# **WATER/WASTEWATER REPORT**

Claremont Business Park 2

## **A RESUBDIVISION OF TRACT C OF CLAREMONT BUSINESS PARK FILING NO. 2**

**Revised NOVEMBER 2019**

PRELIMINARY PLAN

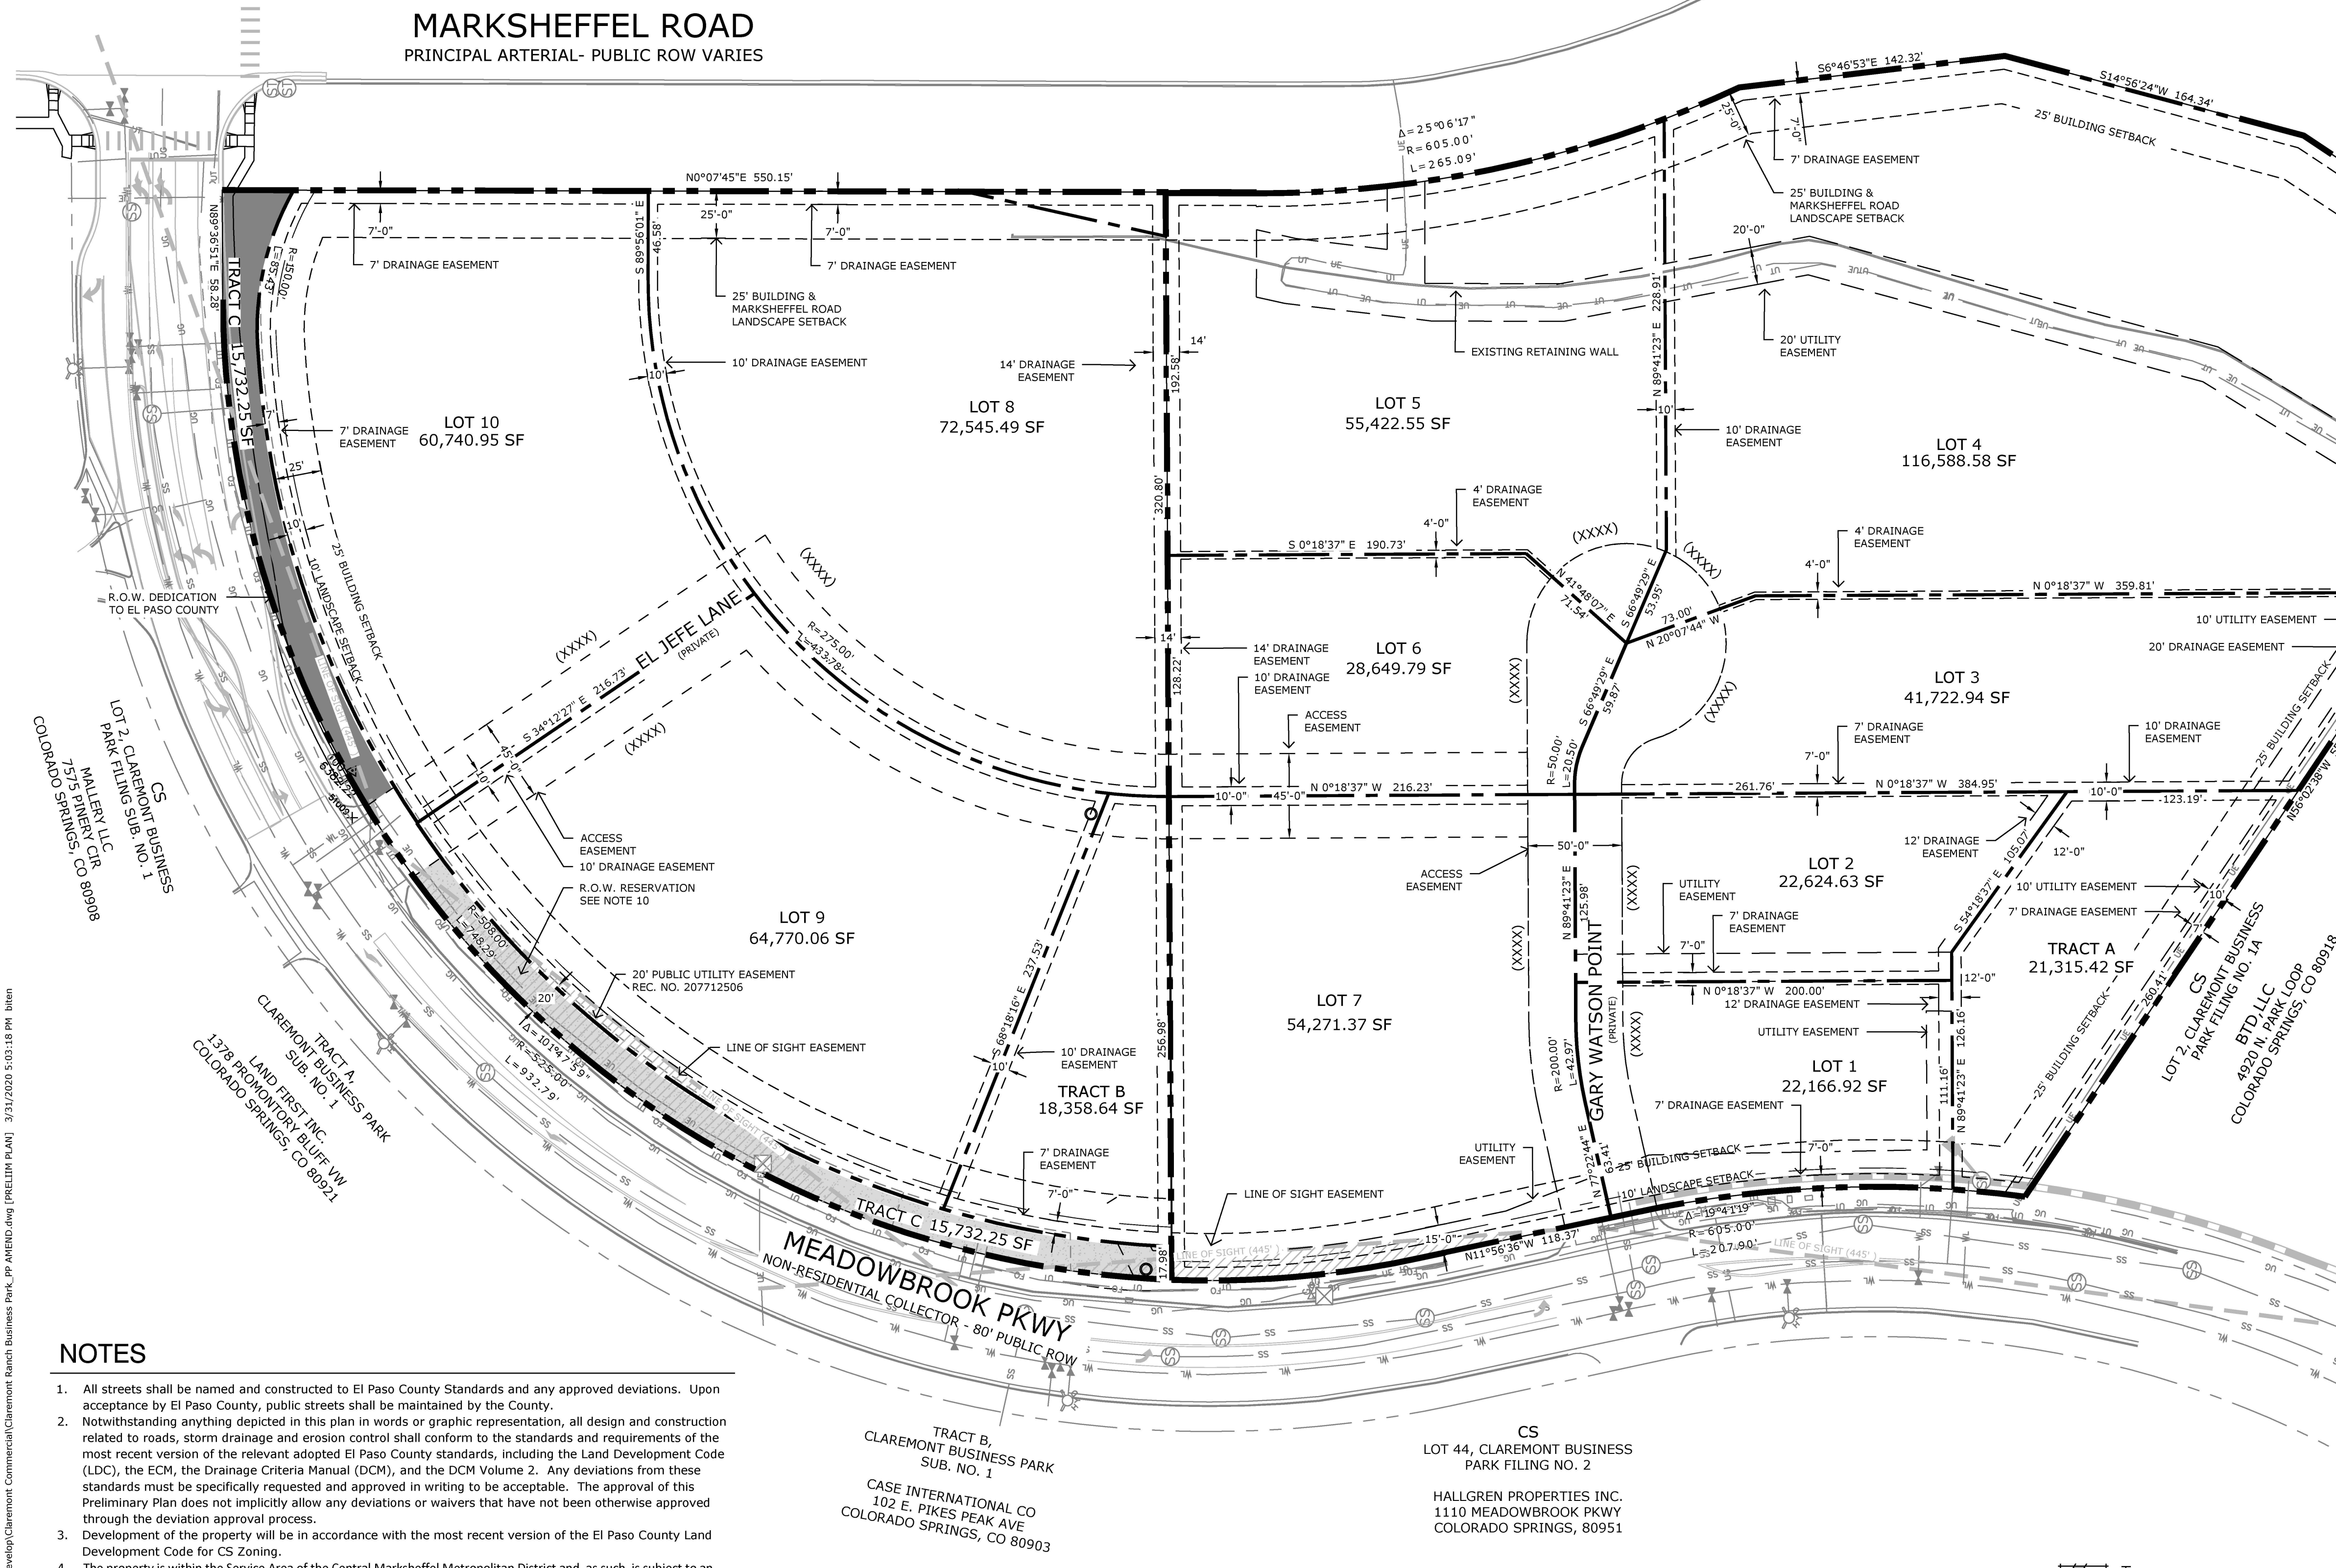
Revised Per the prelim plan, 10 lots are proposed. Please revise
